From: Holmstrom, Rick <HolmstR@wsdot.wa.gov>
Sent: Wednesday, September 24, 2014 8:20 AM
To: Kaycee Hathaway; Christina Wollman
Cc: Gonseth, Paul; Hicks, Bill; Seaward, Mike; Kroll, Chris
Subject: I-90 Vantage Boat ramp short plat
Attachments: Deed 1-D.PDF; Deed 1-D Boundary Trace.pdf; 201409240700.pdf; Vantage 2014.pdf; Sheet 1 of 5 (MP 136.18 to MP 136.56) LE 420+00 to LE 440+00 (Wanapum Rd Interchange).TIF

WSDOT finds ownership issues with this proposal. Our records indicate that WSDOT owns a significant portion of this land. From the proposed short plat, it is the majority of lot 3. I have attached the conveyance deed (AFN 280710) and boundary trace of this deed. We have no records indicating other than our ownership. Also attached is the GIS parcel mapping which more or less, is consistent with our records.

**BOAT RAMP SHORT PLAT**

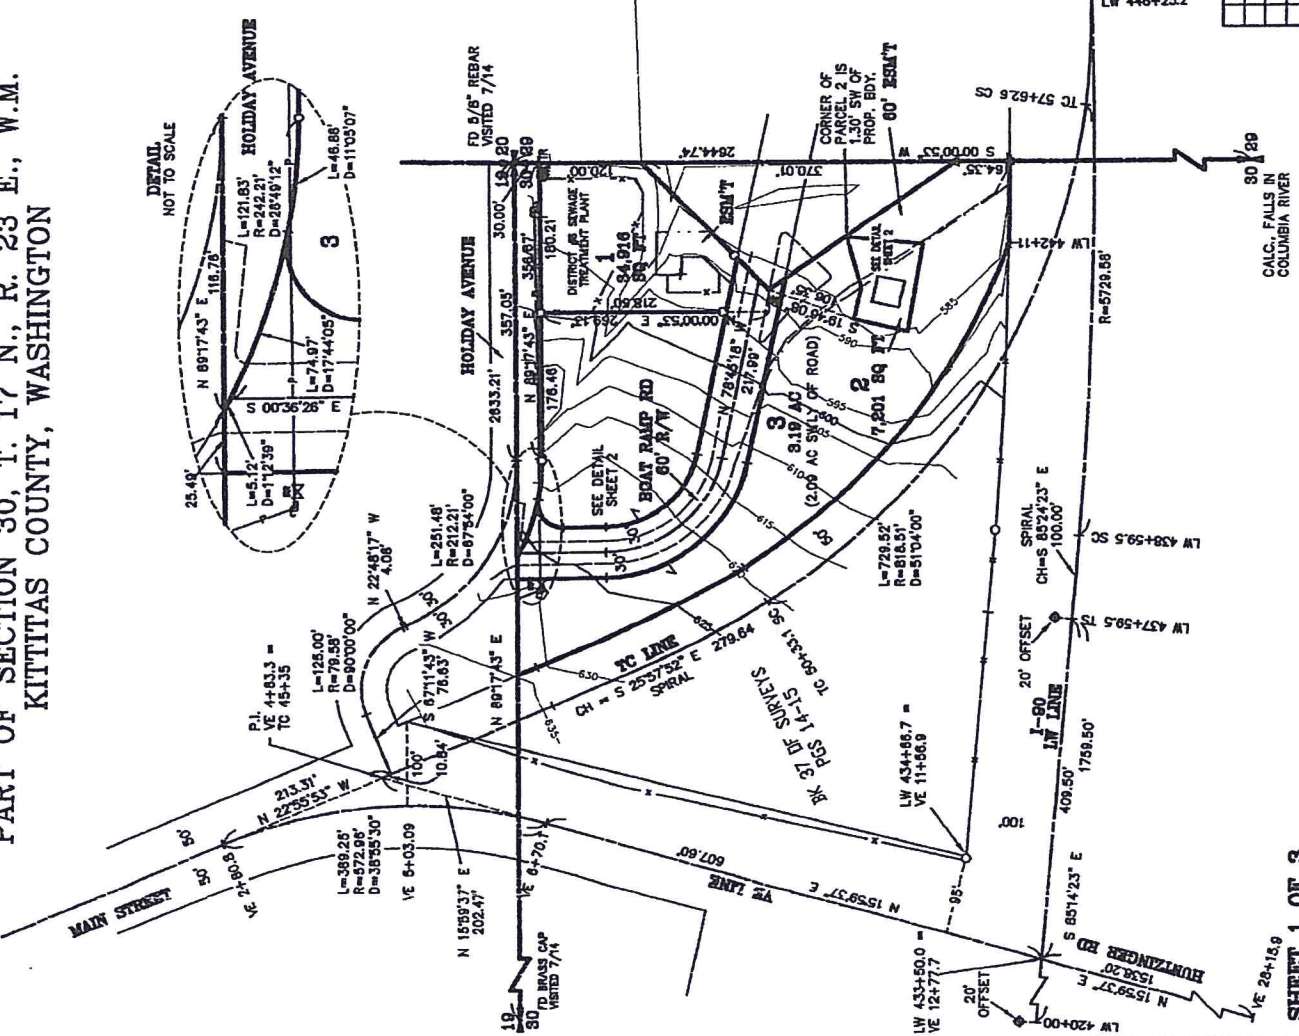
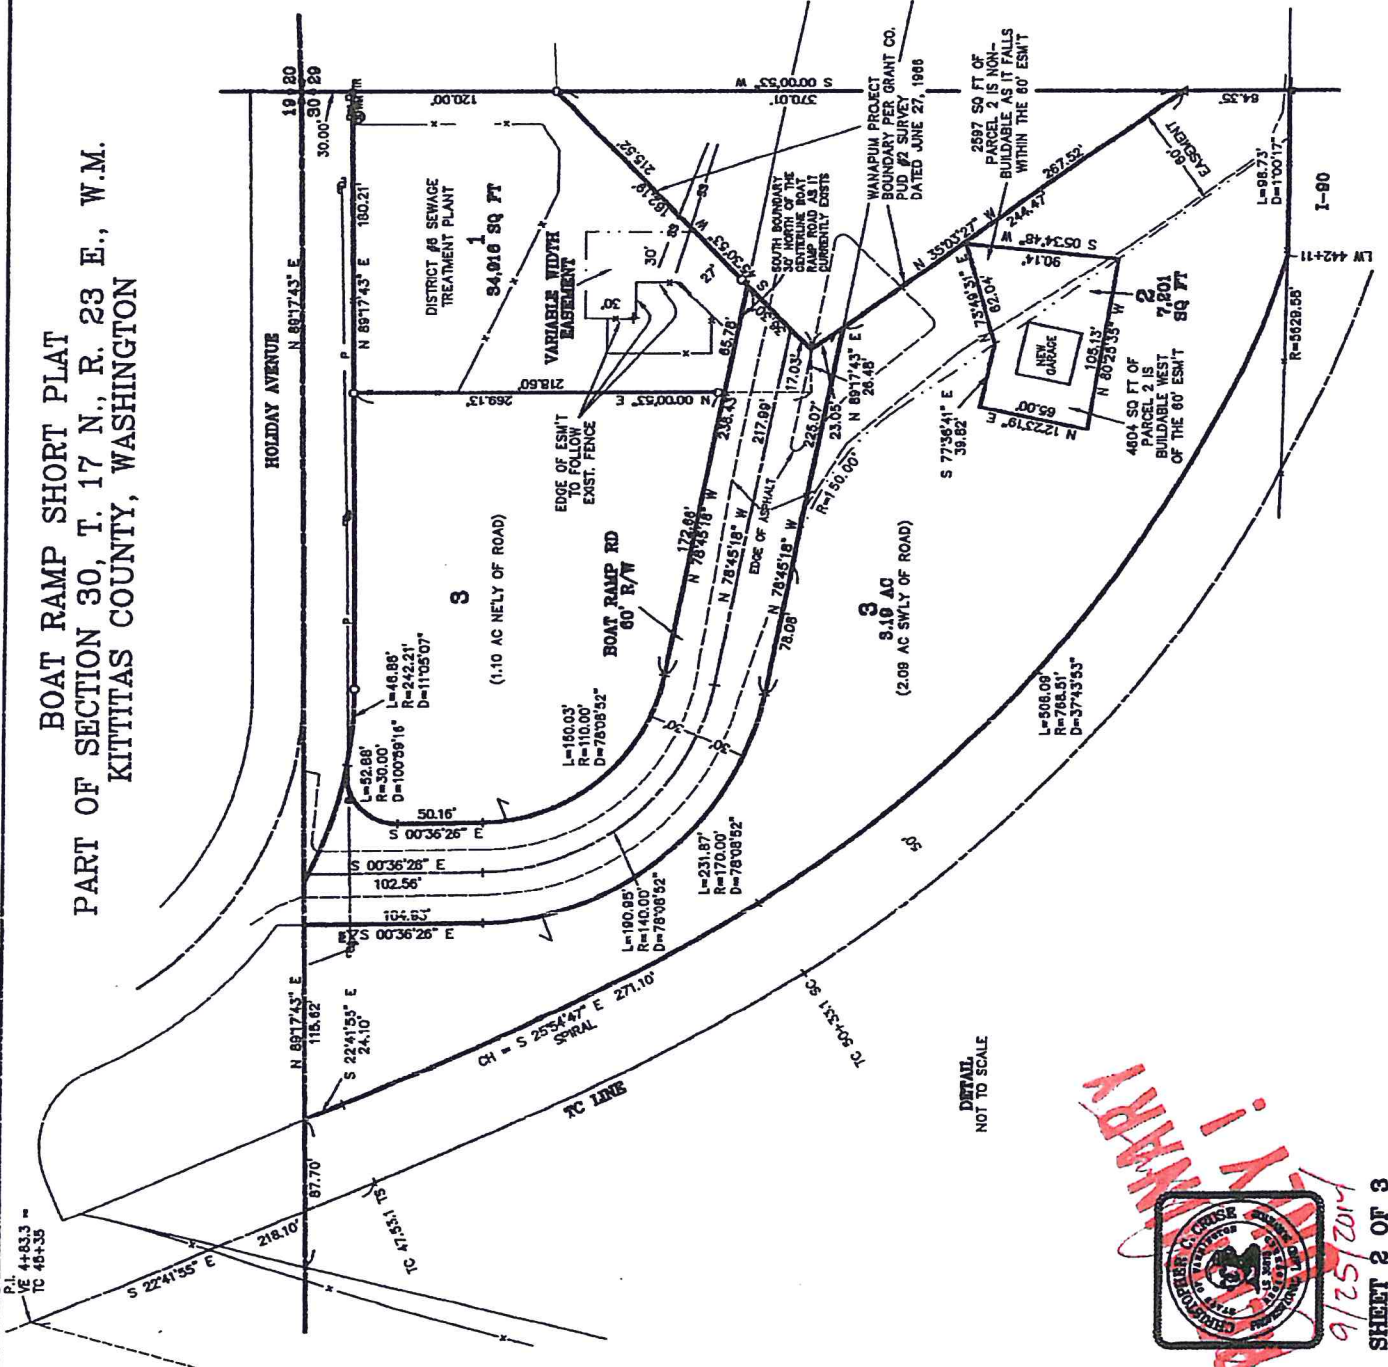
In the absence of a deed or some other instrument indicating otherwise, WSDOT is the owner of the majority of this property in the short plat.
This short plat cannot move forward.

Comments are due next Monday. WSDOT recommends the County either suspend or terminate this proposal. If the County or proponent has records to indicate otherwise, please provide us the appropriate document and we will review accordingly.
